Application by Highways England for an Order Granting Development Consent for the A303 Amesbury to Berwick Down

**SUBMISSION FOR DEADLINE 7 (09 August 2019)
ON BEHALF OF THE
HISTORIC BUILDINGS AND MONUMENTS COMMISSION FOR
ENGLAND
(HISTORIC ENGLAND)
("HBMCE")**

PINS Reference No: TR010025

HBMCE Submission for Deadline 7 (09 August 2019)

Drawing Title
STRUCTURES DRAWINGS
WESTERN TUNNEL PORTAL
REGULATION 5(2)(o)
SHEET 8 OF 13

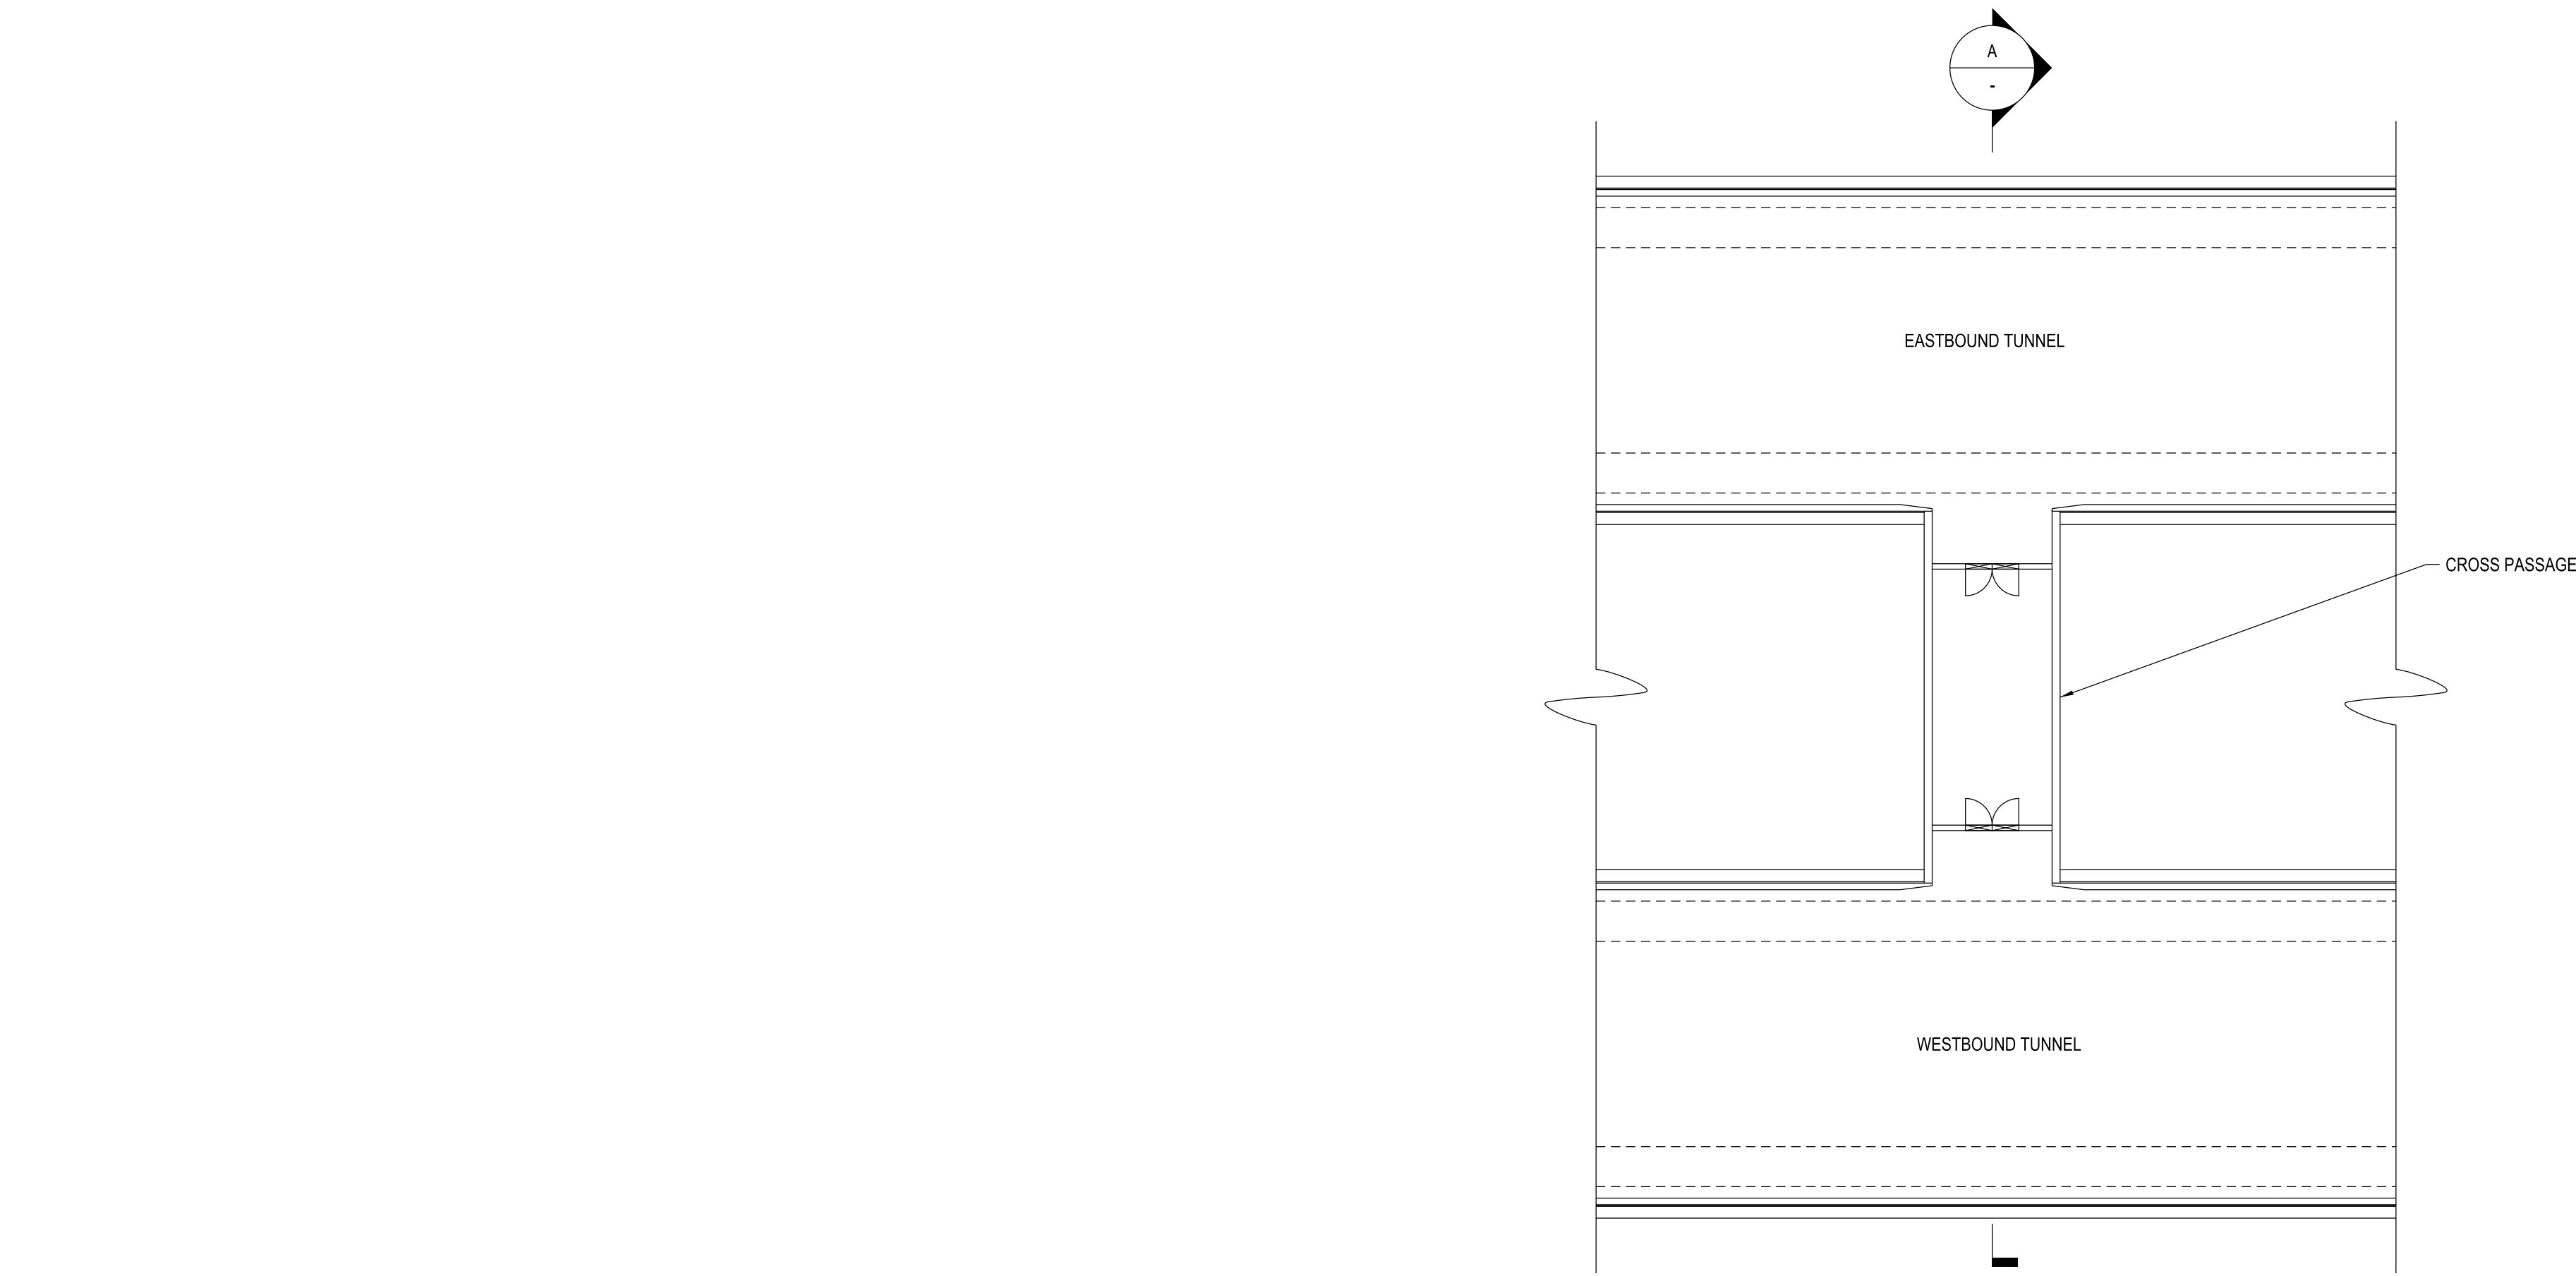
2.11. We highlighted in our Relevant Representations and have subsequently continued to query the reference to the proposed limit of deviation of up to 200m for the proposed western portal. Whilst we welcome the clarification in the latest updated version of the draft legal document that the limits of deviation are no longer to be taken as being “approximate”, we remain concerned as to the impact that the deviation may have on the western and eastern portals and to a lesser extent Green Bridge 4 and Longbarrow junction.

2.12. The lack of design details relating to these elements does not provide clarity over the impacts the deviations could have. We would like Highways England to provide this clarity (through visualisations or written clarification of impact). We remain unclear as to how the visual impact of the Scheme would change if significant changes to the length of the tunnel were made. In a situation where the extent of deviation utilised were such that it would necessarily result in a reduction of the length of the tunnel canopy (extent of cut and cover section of cutting Work 1E), we are unclear as to what visual

impact this would have. We have not been able to identify a design commitment or principle that relates specifically to the design vision for portal design incorporating “grassed canopies to conceal them within the landscape” (OEMP 4.2.7 c) as illustrated in Sheet 6 of the Engineering Section Drawings, and Sheet 6 of the Works Plans. We remain unclear as to how the conclusions of the HIA, which we understand has assessed a 200m canopy, have taken the limits of deviation into account.
